Your Ref: OWPC21969
Our Ref: M/24/19/PL 06-03-2019
Please ask for:
Andrew Wood

Replacement residential dwelling. This application may affect a Public Right of Way.

3 The Hard Elmer

PROPOSED FIRST FLOOR PLAN 1:50

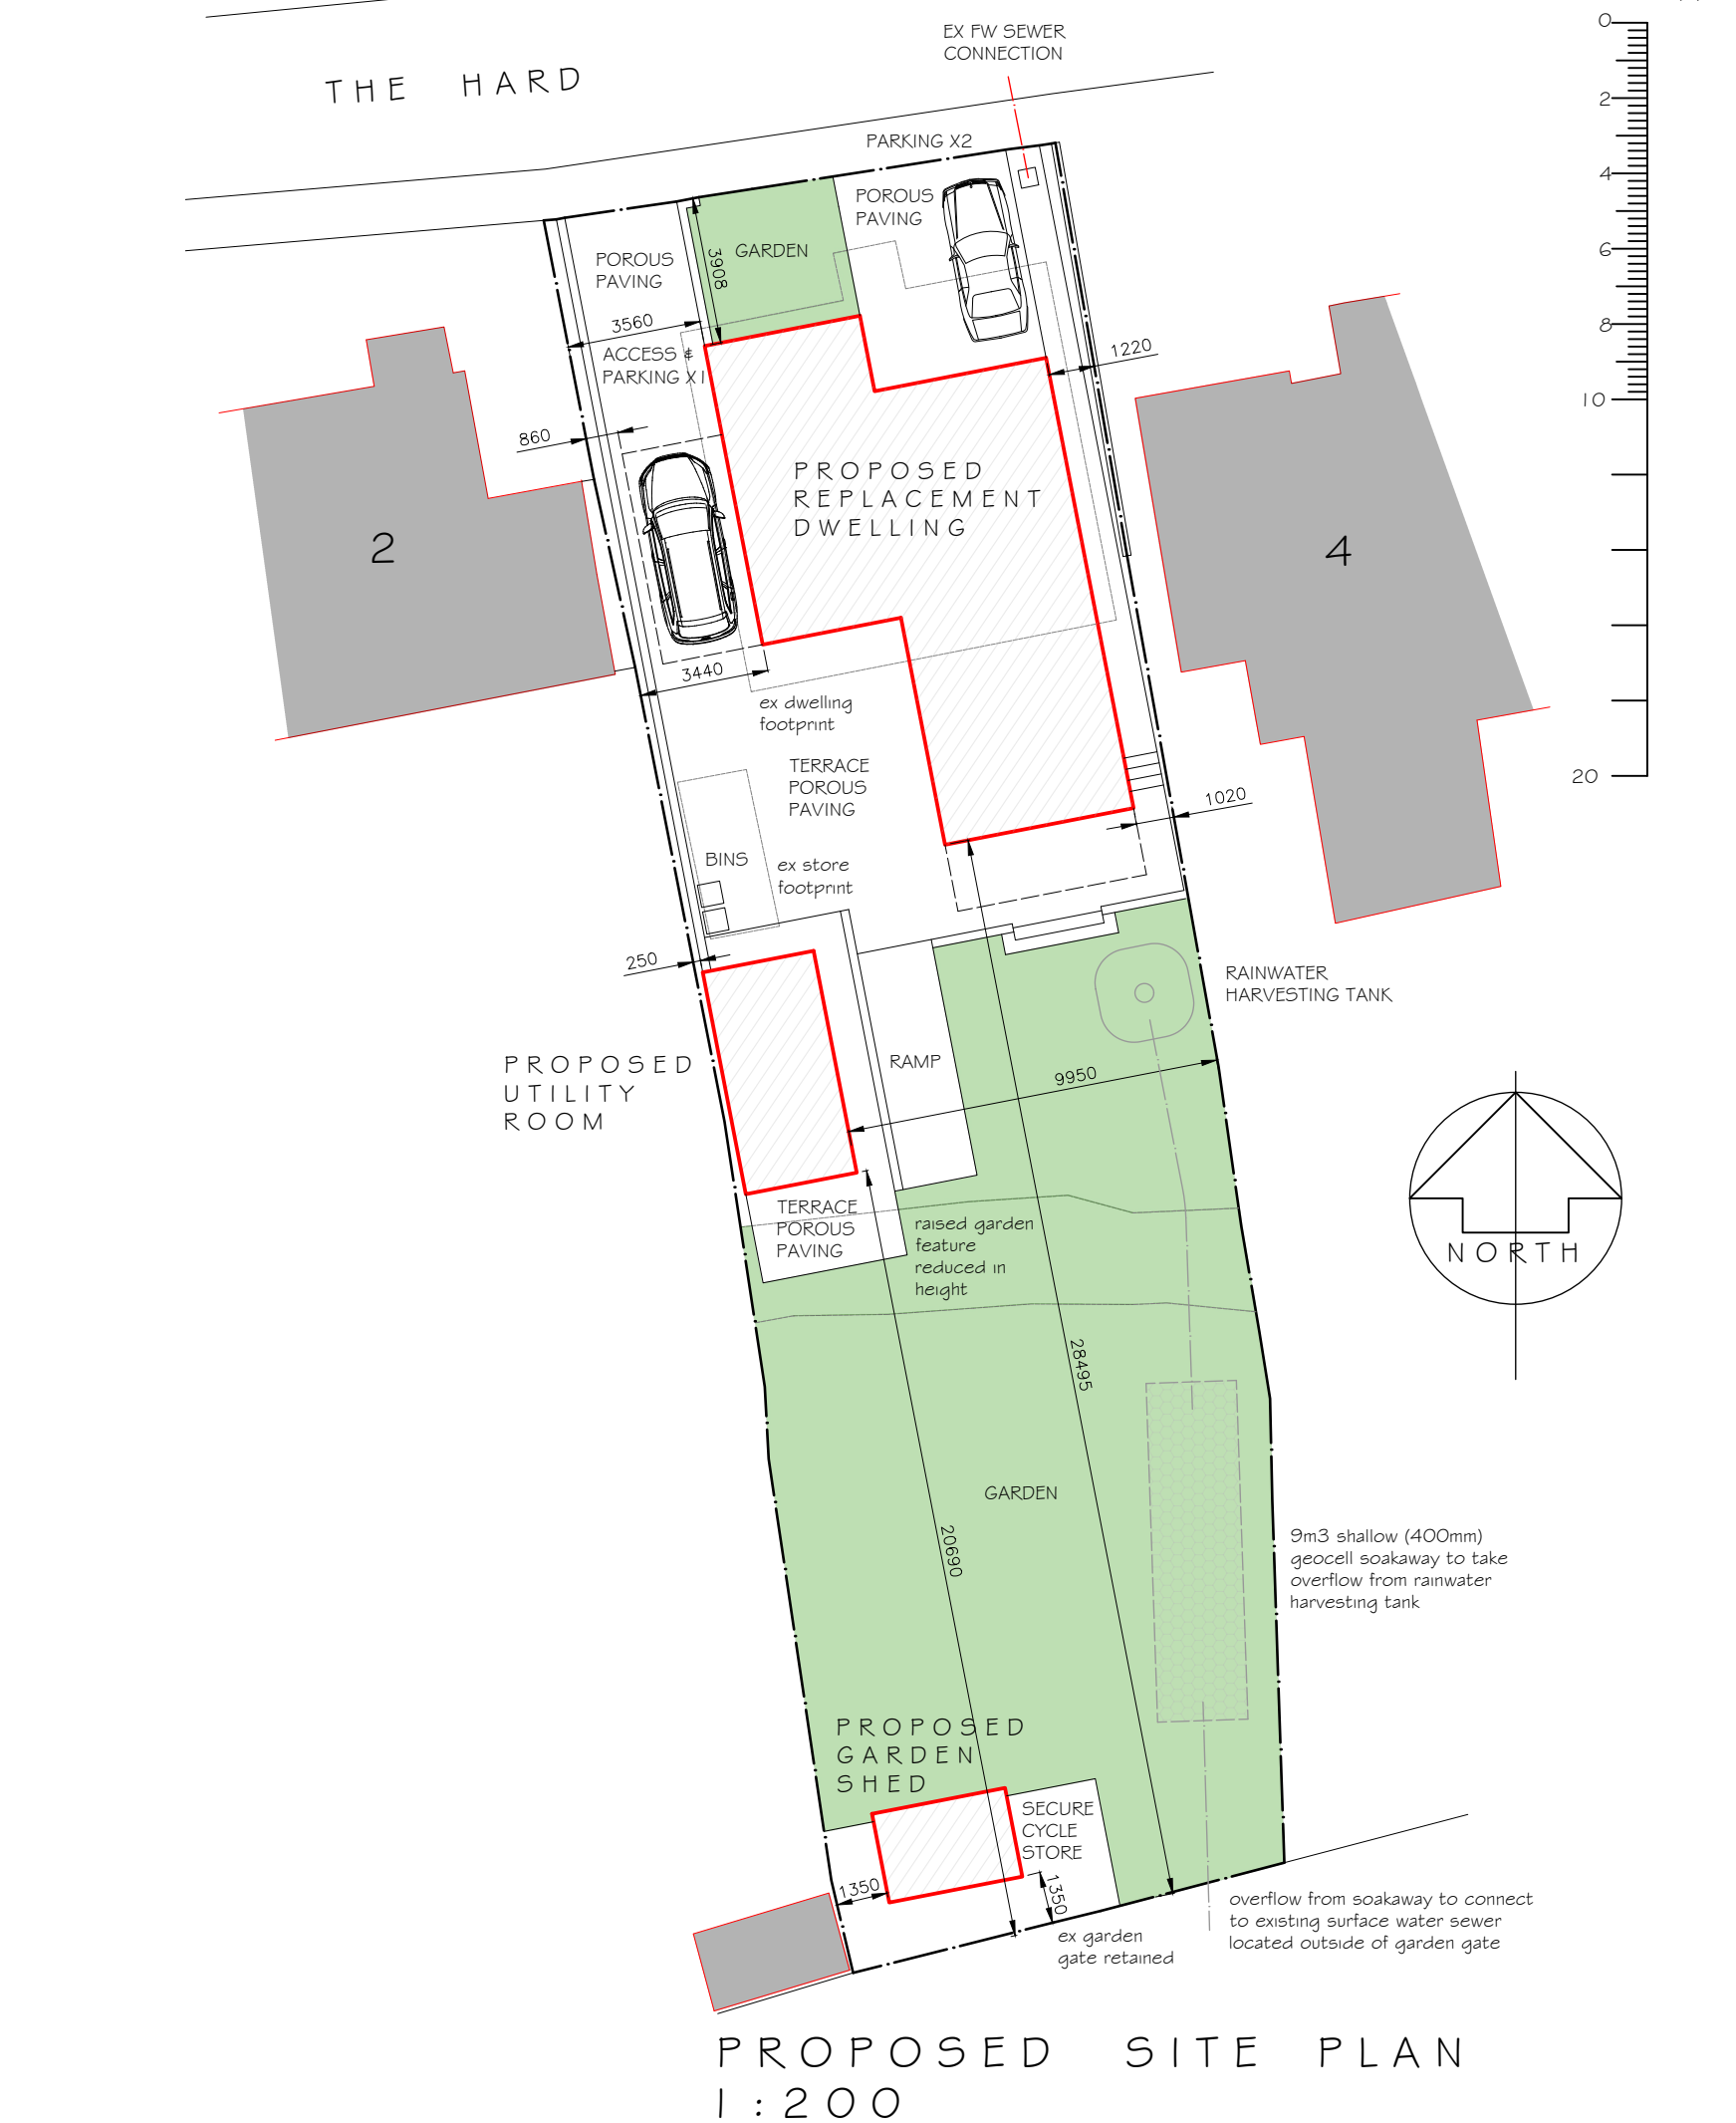
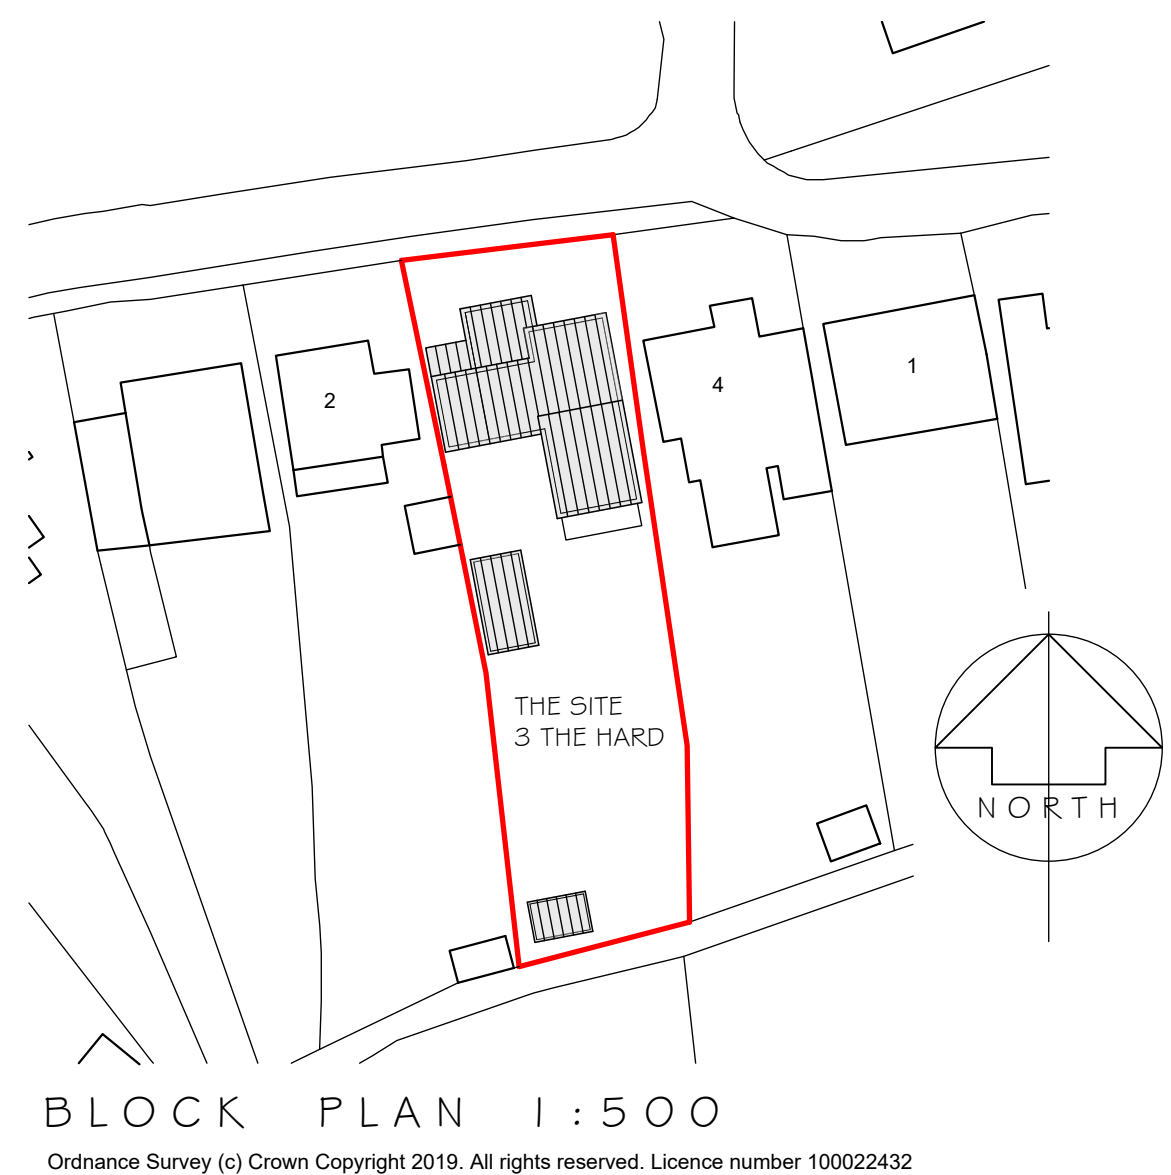
Elmer Sands Limited acts in the interests of the wider membership of the Elmer Sands Estate and as such registers an interest in the issue of the sea defence bund running east to west through the garden of 3 The Hard and adjoining properties. The plans show a reduction in height of this bund, possibly levelling? This forms a long standing second defence of sea ingress in the event of over-topping of the primary beach sea defence and as such it is a second line of defence to sea ingress generally across the estate.

Whilst changes have been made to the sea defences over the years a breach remains a current possibility, certainly before improved sea defences are delivered hopefully later this year. As a result ESL would not favour a reduction in this secondary defence before a proper assessment has been carried out and the Environment Agency has confirmed its obsolescence.

This aspect may be incidental to the general building consent but if planning permission is approved it is suggested that a condition be included that this issue is investigated prior to any agreement to reduce the height of this bund.
